Sydney Grammar School Weigall Sports Complex (SSD-10421)

Response to Request for Information

15 June 2021 | 19049

DPIE RTS2 ISSUE 2(A)(B)

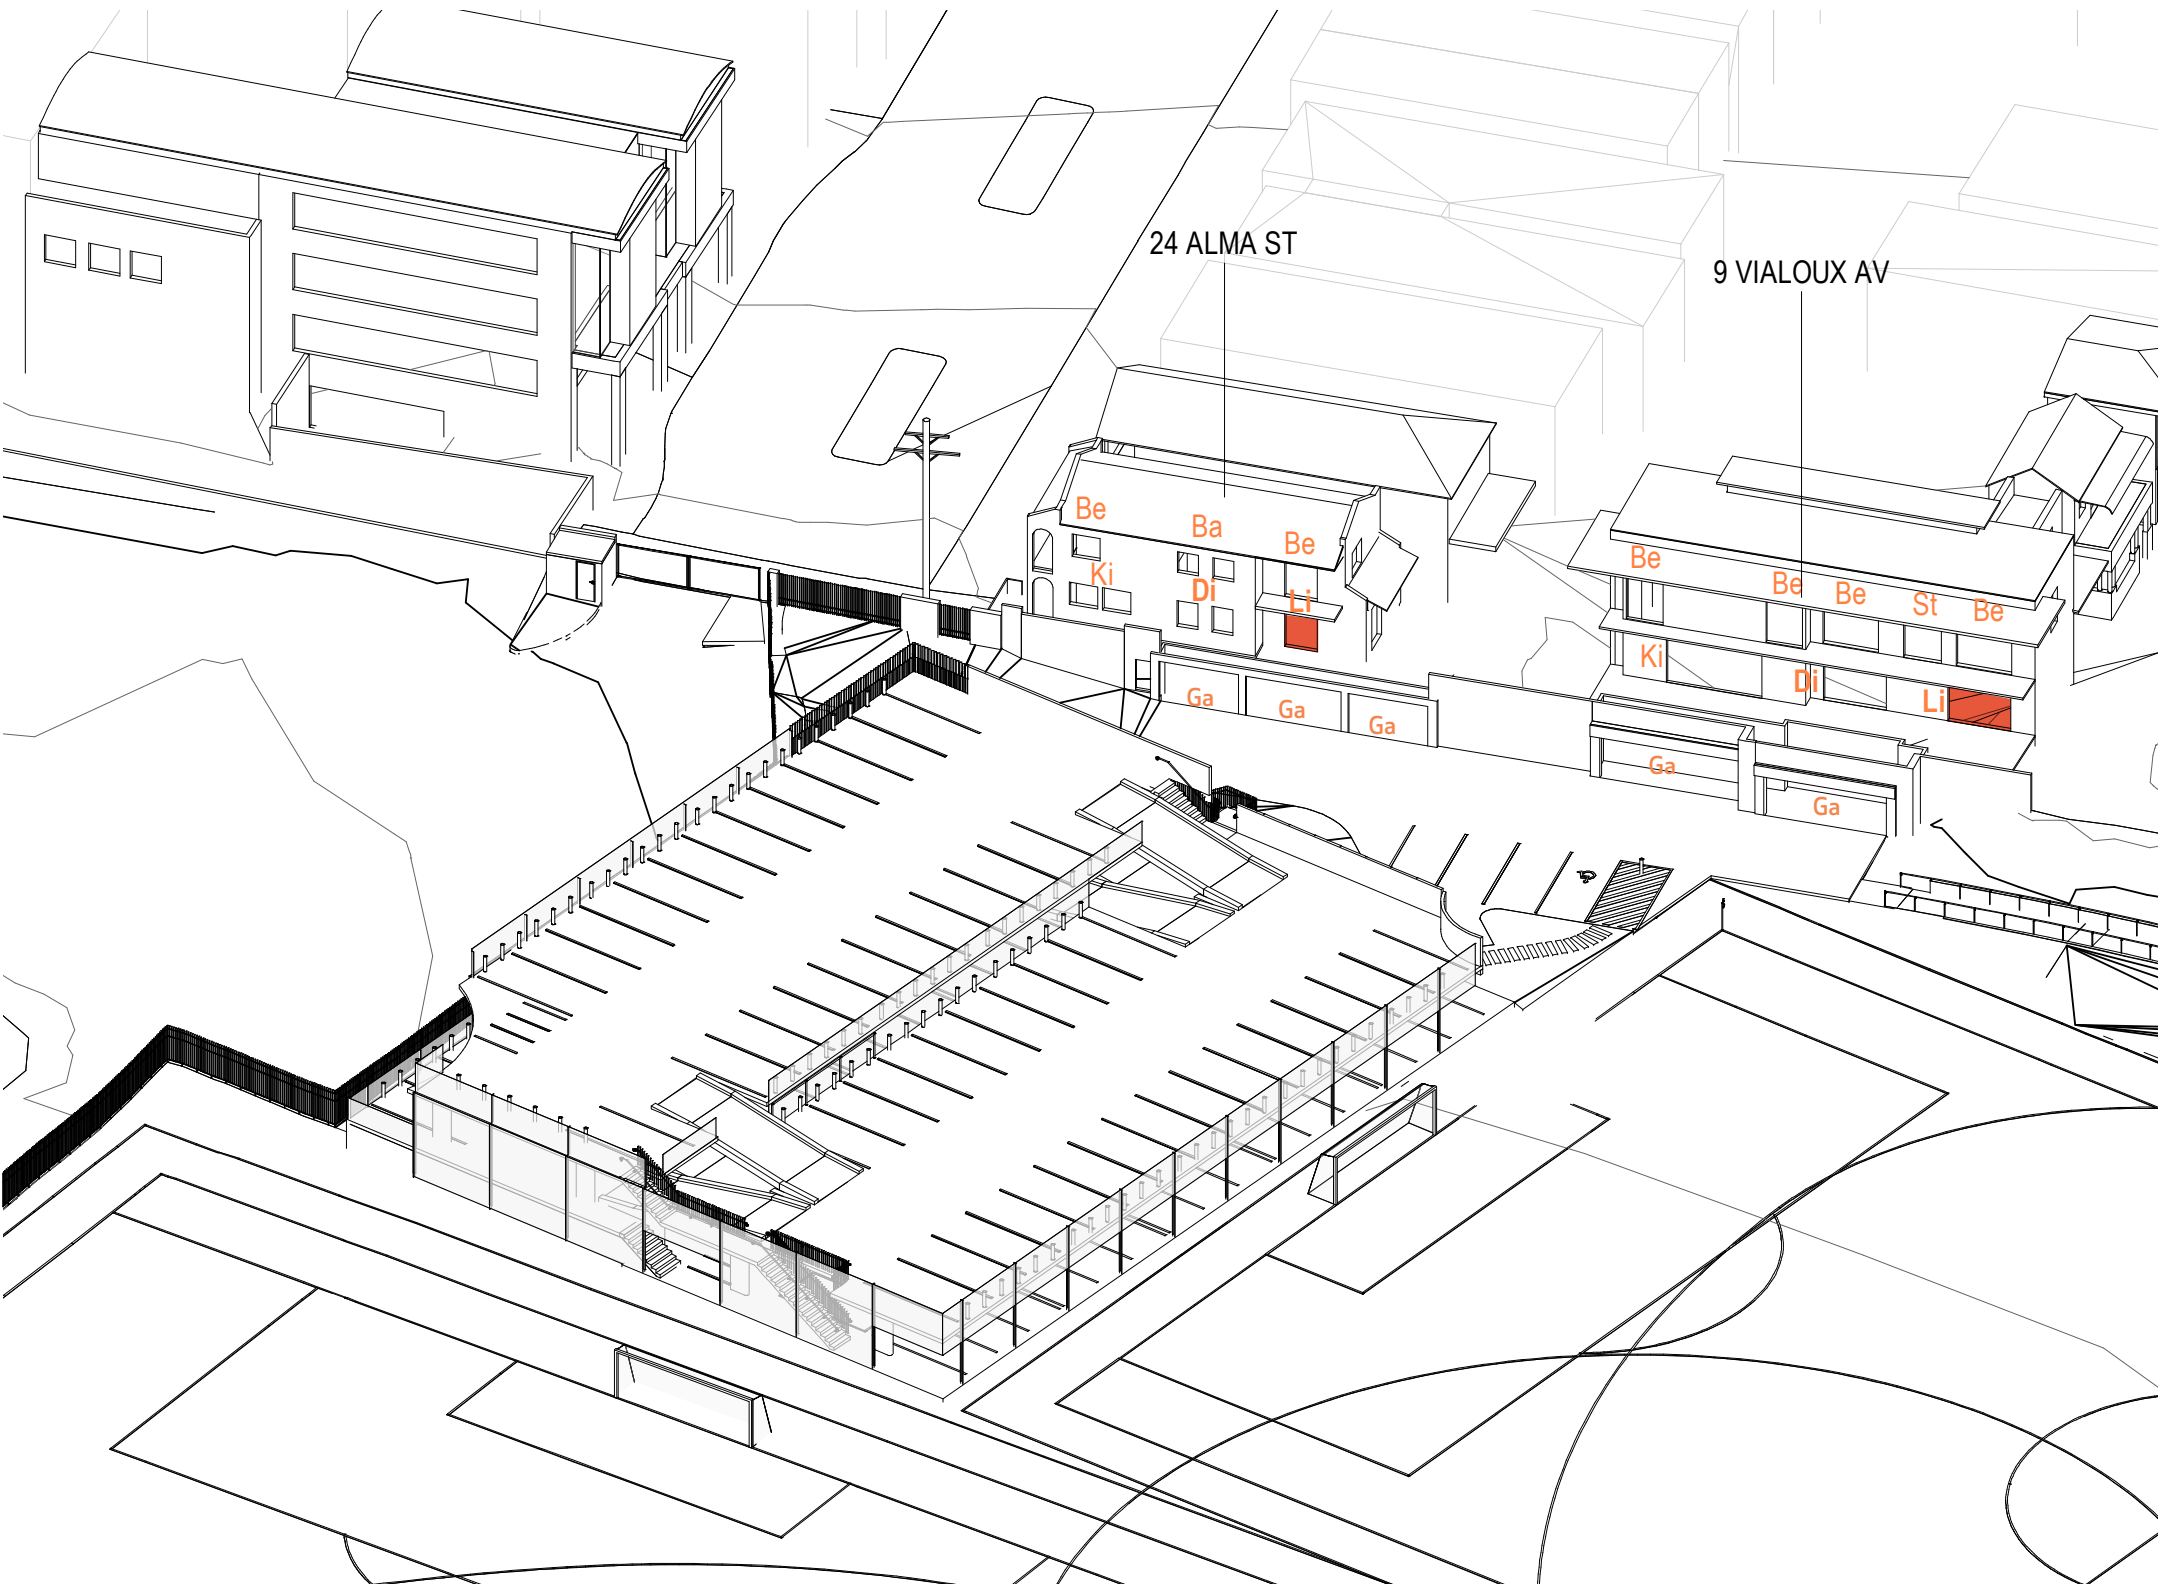
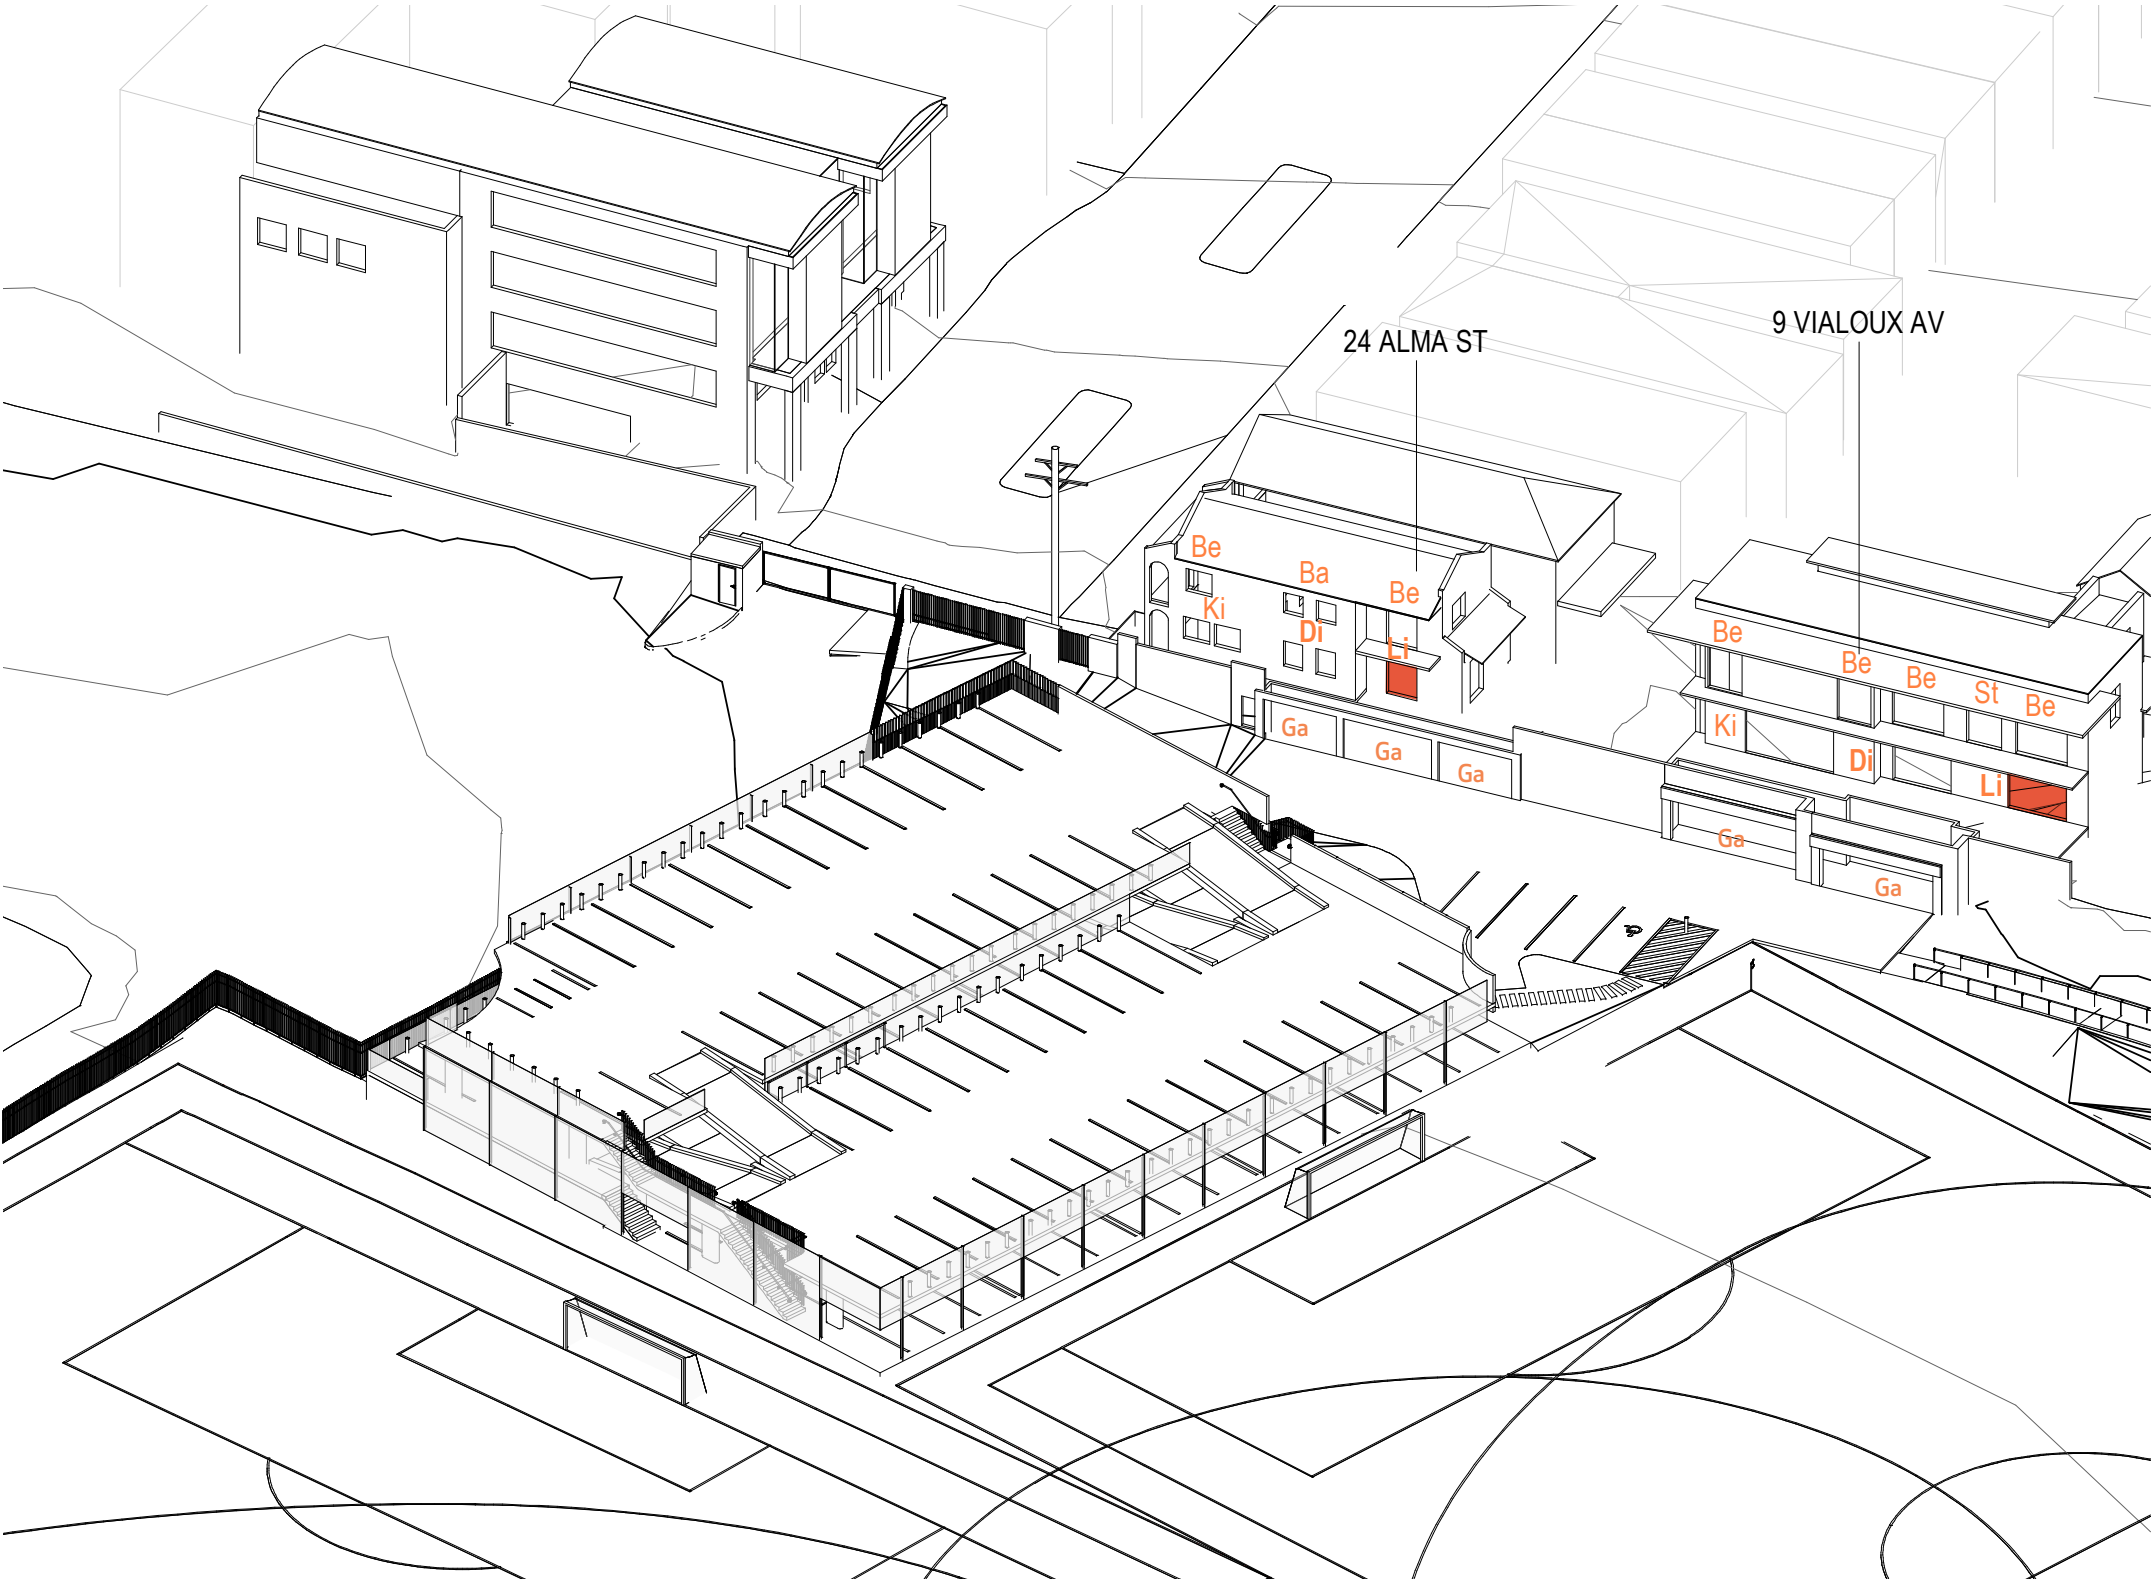
- a) The nature/use of the rooms with windows facing Building 2 and the associated impacts.*
- b) Impacts of Building 2 on solar access, view and outlook of the abovementioned properties.*
- c) Impacts of light-spill from cars (due to headlights) on the Building 2 roof top car park.*

Solar access: The sun's eye studies by AJ+C (**RFI Appendix B**) show that from 9.00am to sometime after 2.30pm in midwinter (at least 5½ hours), the proposal will not reduce solar access to any windows or open spaces at 9 Vialoux Avenue. At 3.00pm only, the ground floor living room will be overshadowed by Building 1. Given the short duration of impact, the shadow impact on 9 Vialoux Avenue is considered to be minimal and reasonable.
